From: Stephen Brooker [REDACTED]
Sent: 08 April 2019 13:25
To: Simon Davis <Simon.Davis@arun.gov.uk>
Subject: RE: BR/326/18/PL

The royal Hotel - BR/326/18/PL

The application is for the refurbishment of the existing building, external alterations, extensions and reconfiguration of a previously permitted conversion. The proposal is to provide an A3 restaurant and 27 flats.

TYPICAL WINDOW DETAIL

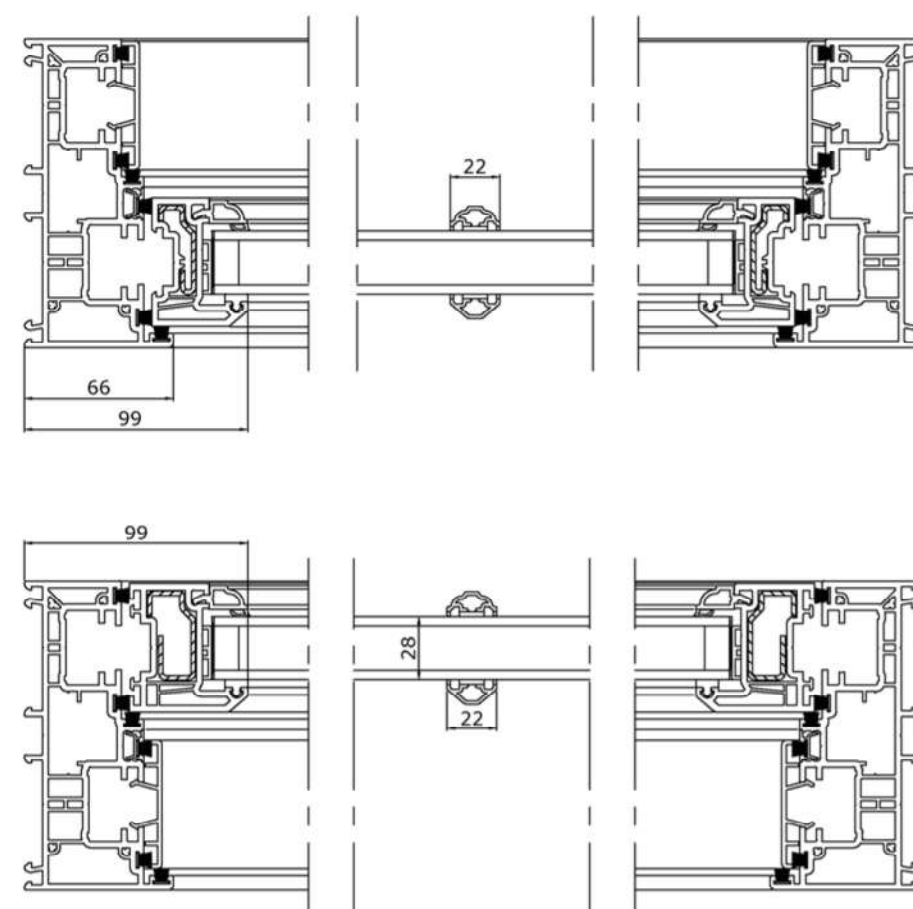
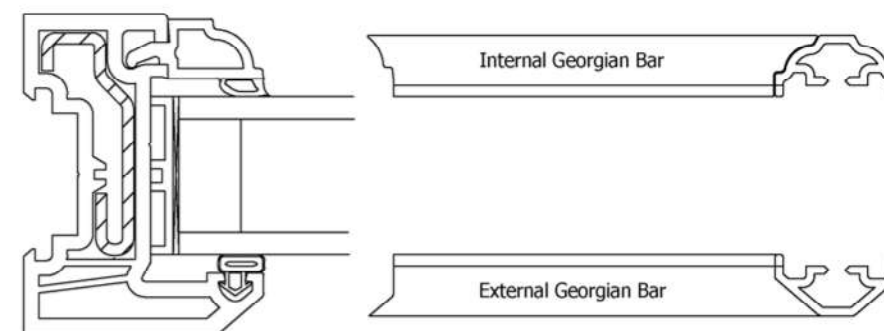
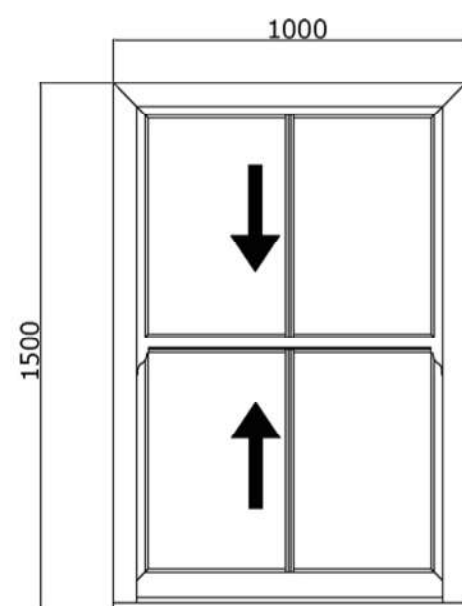
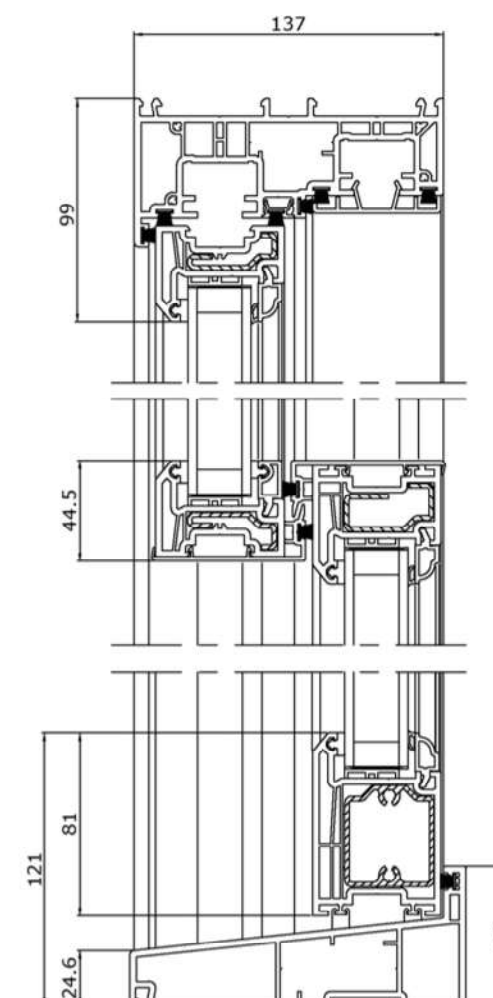
- Can you confirm that the sash windows will be fully sliding. It is not clear from the drawing.
- Would prefer to not have stick on glazing bars but this can be accepted and the window details are otherwise good.

The fenestration of the building will have a significant impact upon the success of the works, and should closely reflect the remaining traditional windows. It is considered that the best approach would be to use sliding sash windows. The windows should also be such that the design/measurements closely reflect the existing, remaining traditional windows.

- 1 Yes we agree to an extension of time to 22/4/19
- 2 The render is proposed be RAL colour 9003 (Signal White), it will be smooth finish.
- 3 The windows will be sliding sashes
- 4 We will match the balustrade/railings as closely as possible but are not able to commit to a manufacturer yet, perhaps this could be a pre-installation (rather than pre-commencement) condition.
